COMMUNITY SERVICES DEPARTMENT

October 31, 2019

Subject: Tanja Curtis Minor Subdivision, Review #2 (MS-19-005)

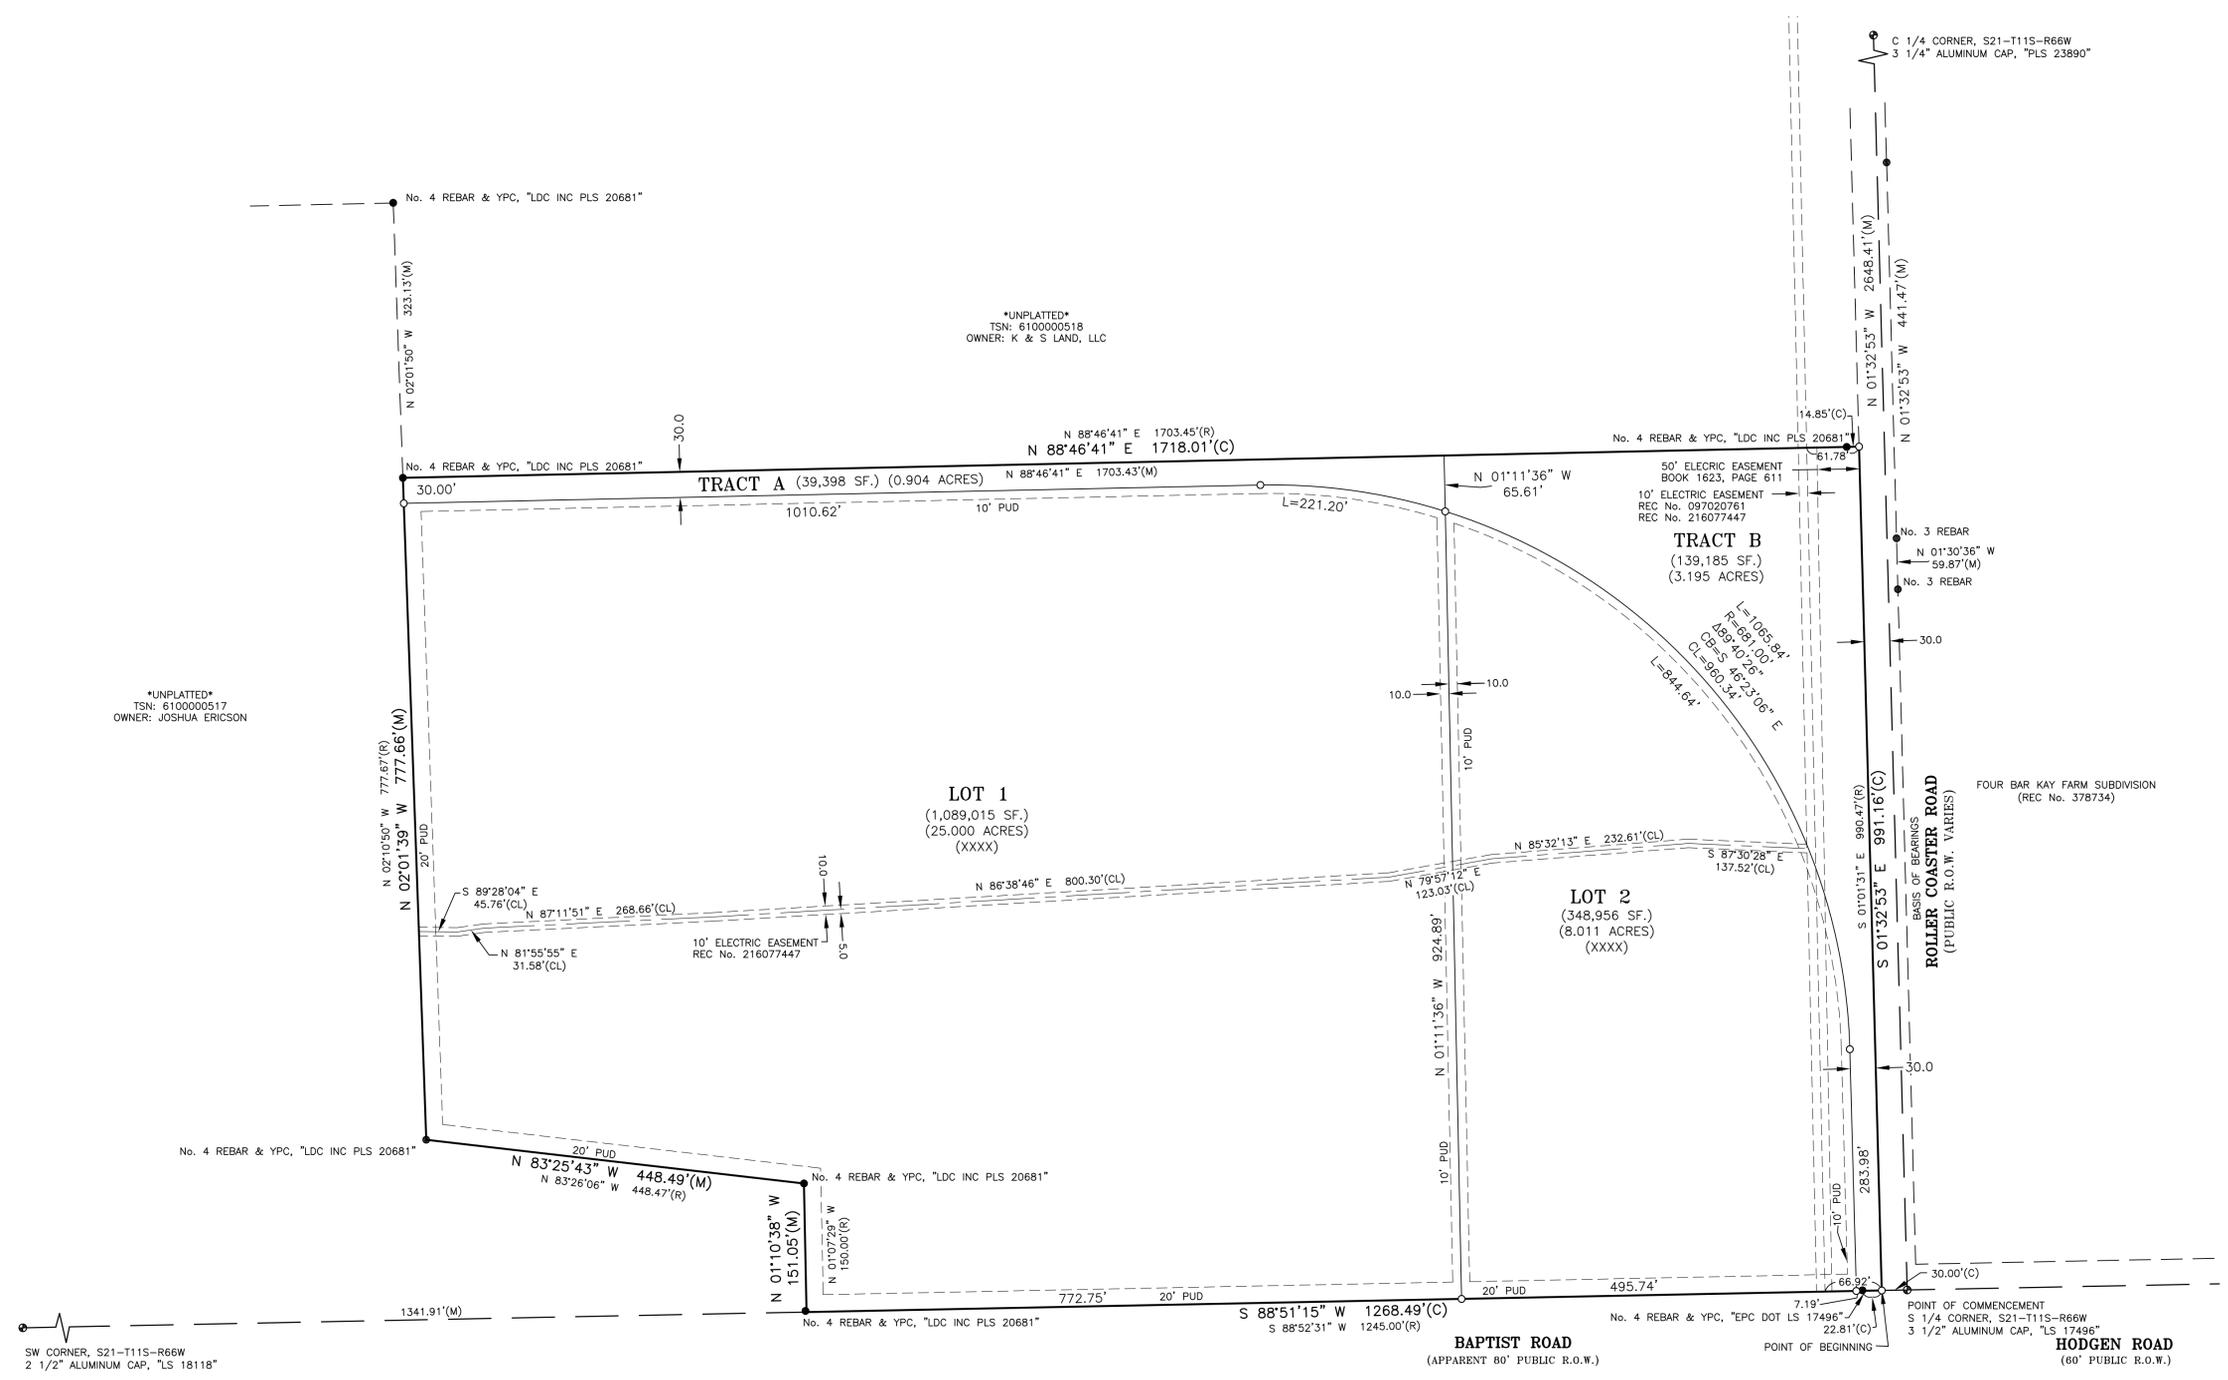
The Community Services Department has reviewed the Tanja Curtis Minor Subdivision development application, Review #2, and has the following additional comments of behalf of El Paso County Parks. Staff has noted that the Final Plat included in Review #2 does not show or contain general notation of the required 25-foot trail easement dedication as noted in the Recommended Motion, as endorsed by the Park Advisory Board in July 2019. This trail easement will provide a critical connection between Fox Run Regional Park and the Fox Run Regional Trail. As such, staff continues to require the dedication of the 25-foot trail easement.

Recommend to the Planning Commission and Board of County Commissioners that approval of the Tanja Curtis Minor Subdivision include the following conditions: (1) Show on the Final Plat and dedicate to El Paso County a 25-foot trail easement along the southern boundary that allows for public access, as well as construction and maintenance of the Fox Run Regional Trail; (2) require fees in lieu of land dedication for regional park purposes in the amount of \$912.”
